**Recommendation:** Refuse

**Applicant:** Mr Brent Glattbach

**Proposal:** Single storey rear extension and canopy over front door – revised scheme of 21/00565/F

Existing & Proposed
 Site Plans

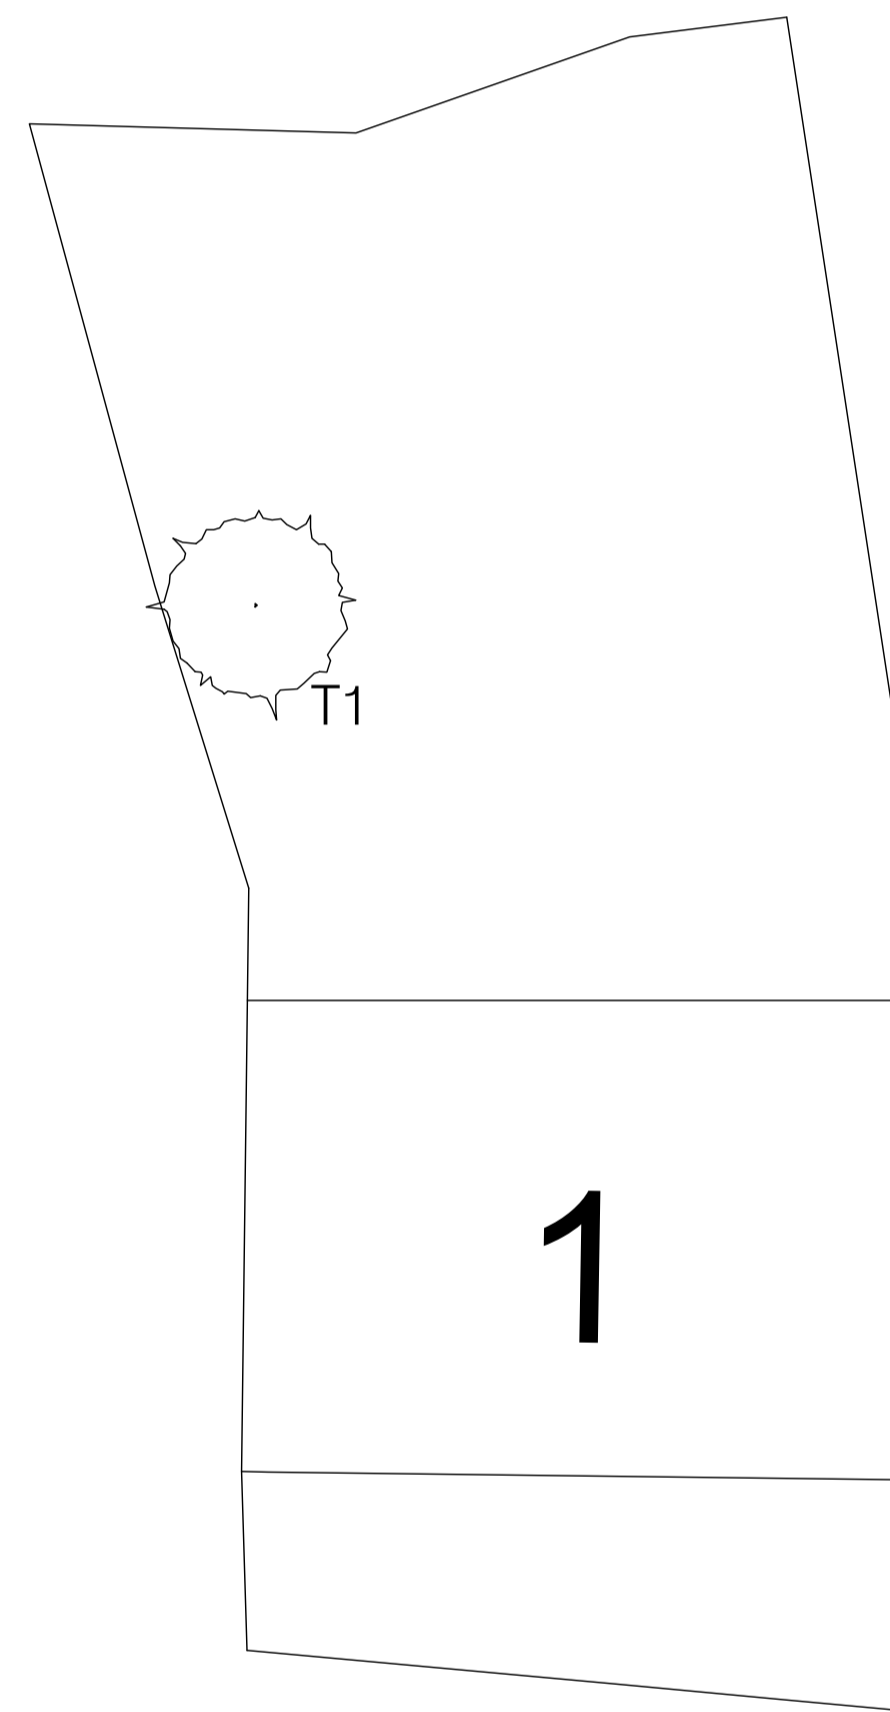
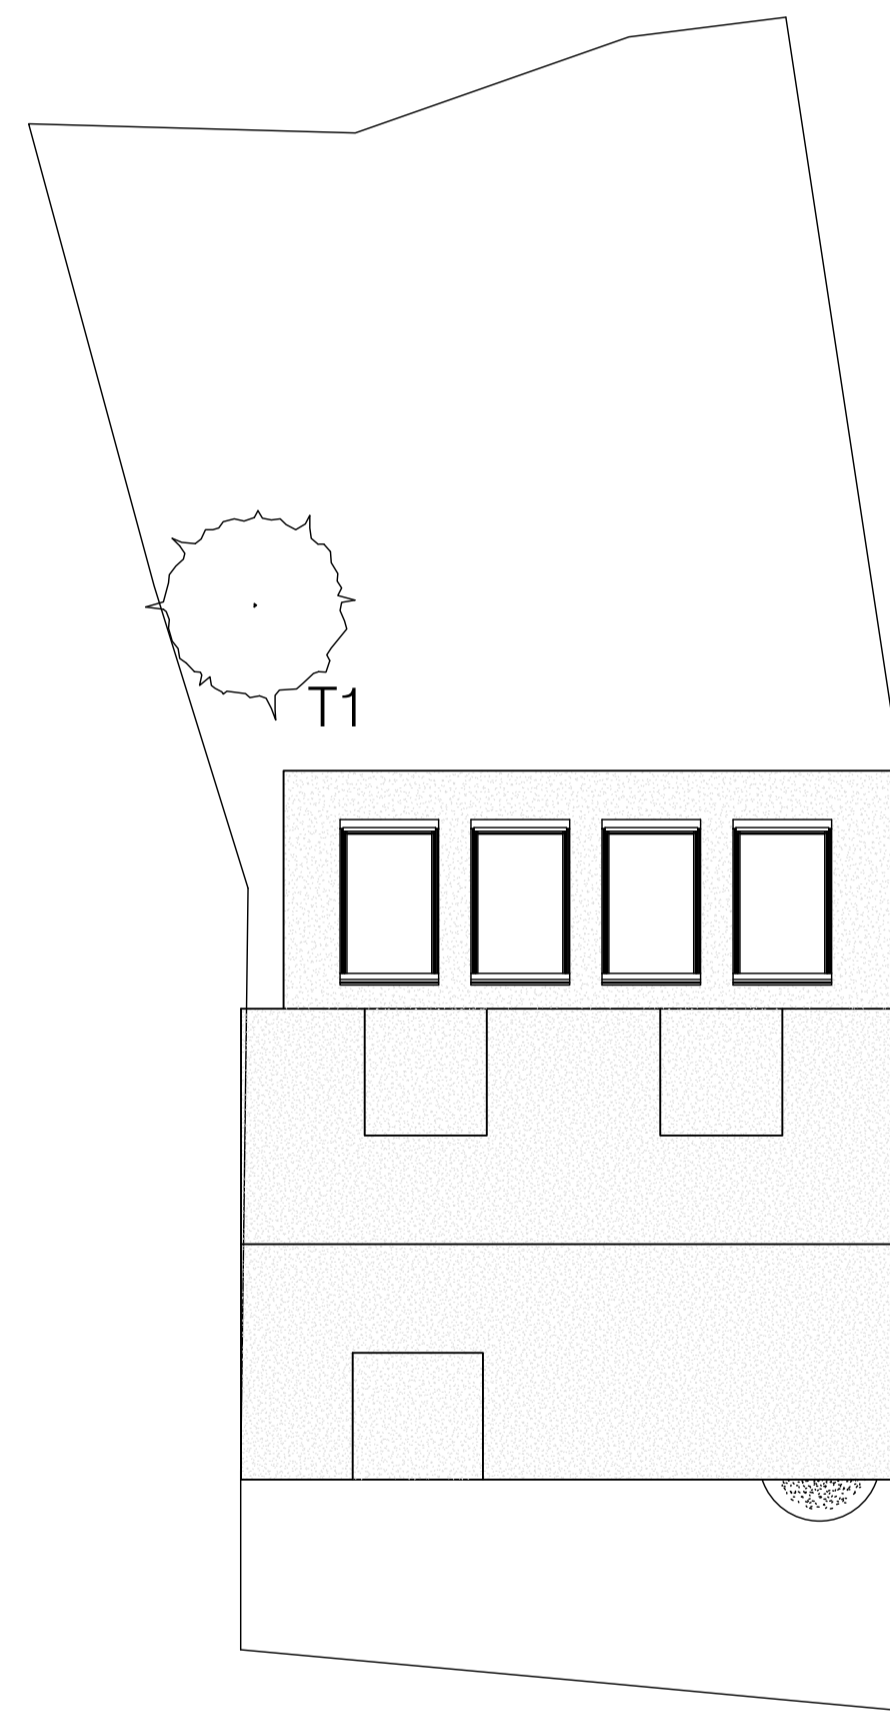
**Rear extension design:** The current design would make a greater impact than the unregistered 2013 scheme as it is heavier and obscures more of the rear elevation. It is possible that the fascia could be quite dominant in southerly views of the rear elevation from the Conservation Area. The proposed extension would cause some harm to the non-designated heritage asset. There would also be some harm to the Conservation Area and the setting of Goodmays, which would be greater if the extension was approved with the heavy fascia seen on the drawings.

- Whilst the proposed extension's ironstone façade / external finish would match that of the original dwelling and the adjoining properties, the proposed extension's flat roof design would be at odds with the character of host dwelling and the adjoining Listed property, Goodmays. It is considered that the proposed flat roof design would adversely impact the character of the site, Goodmays, and the Conservation Area, and is therefore unacceptable. This harm is compounded by the proposed fascia around the extension, which would be very unsightly and is poor design in itself.

- The proposed rear extension would almost entirely obscure the rear elevation of the host dwelling, as the proposed development would have a total width of 8m, the host dwelling's rear elevation has a total width of 8.7m. However, it has to be recognised that an extension of a similar width could be carried out under the property's permitted development rights.
